From: Anita Gardner
Sent: 20 March 2012 12:23
To: Planning.Responses
Subject: FW: LU/156/11/DOC FW: Littlehampton - Soakaway Tests

From: Mike Burford
Sent: 20 March 2012 12:04
To: Anita Gardner
Subject: RE: LU/156/11/DOC FW: Littlehampton - Soakaway Tests

I refer to your recent e-mail concerning the development on land tot he south of Hearnfield Road,

Littlehampton.

SECTION - PRIVATE DOMESTIC SOAKAWAY

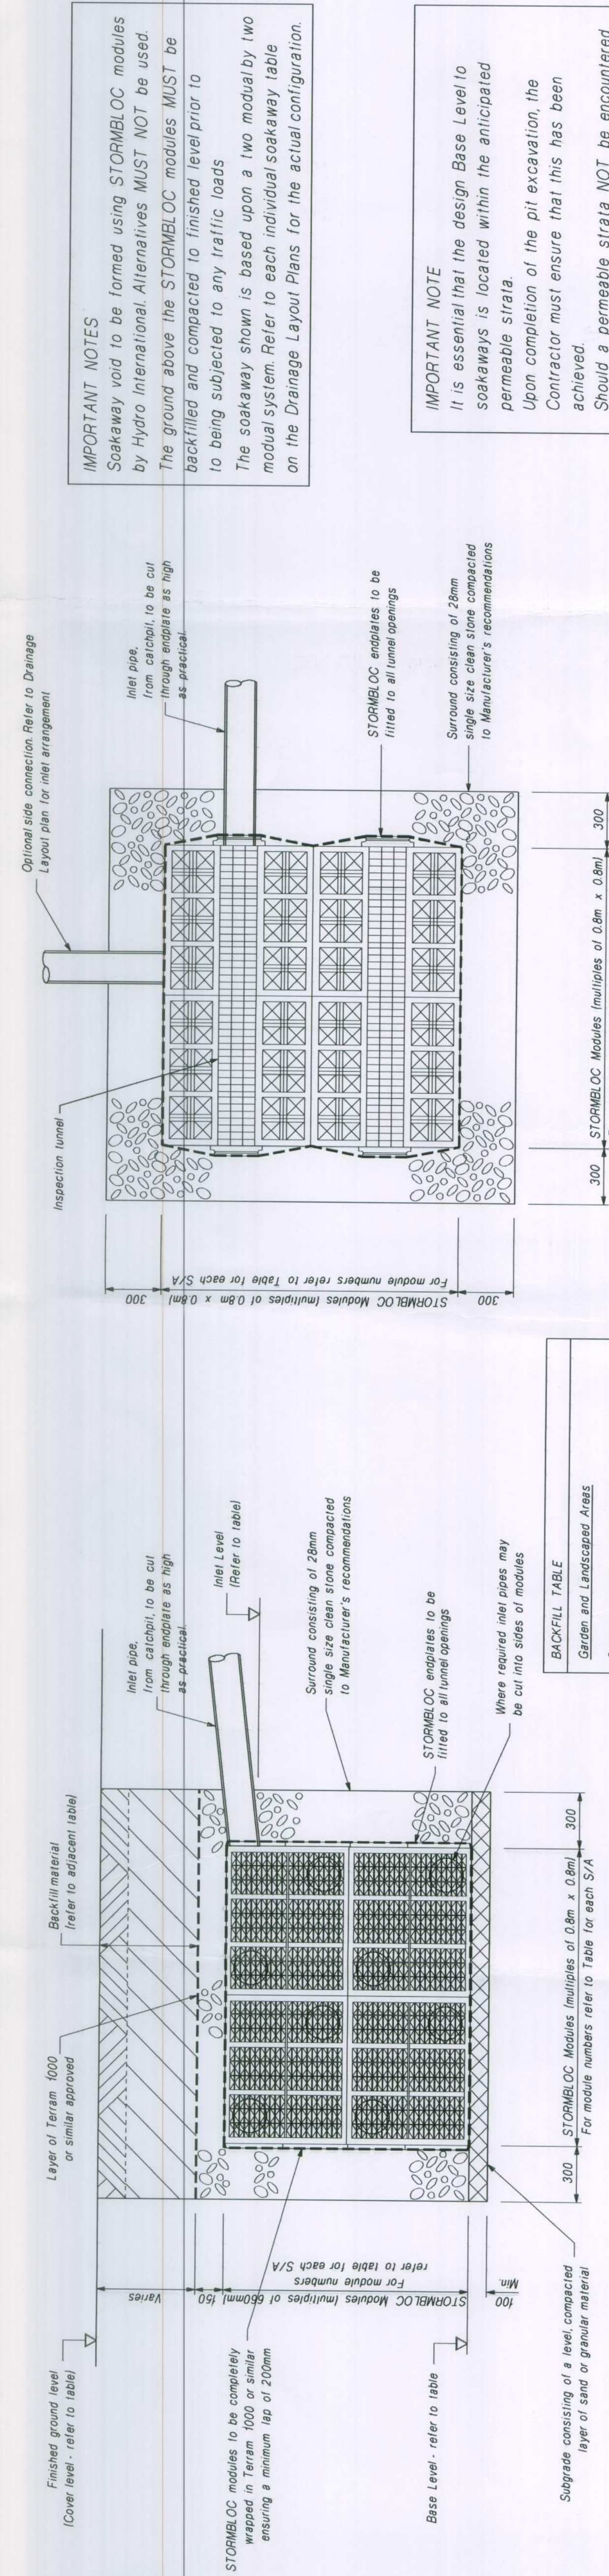
The soakage rates used in the design are 4.78×10^{-5} m/s. This is a higher rate of infiltration than the test results submitted of 1.5×10^{-5} m/s. We will require submissions of design calculations using the test results to confirm that the design is adequate.

The design must contain the 1 in 10 year event between the base of the soakaway and the invert of the inlet. The 1 in 100 year event + 30% must be contained below ground level.
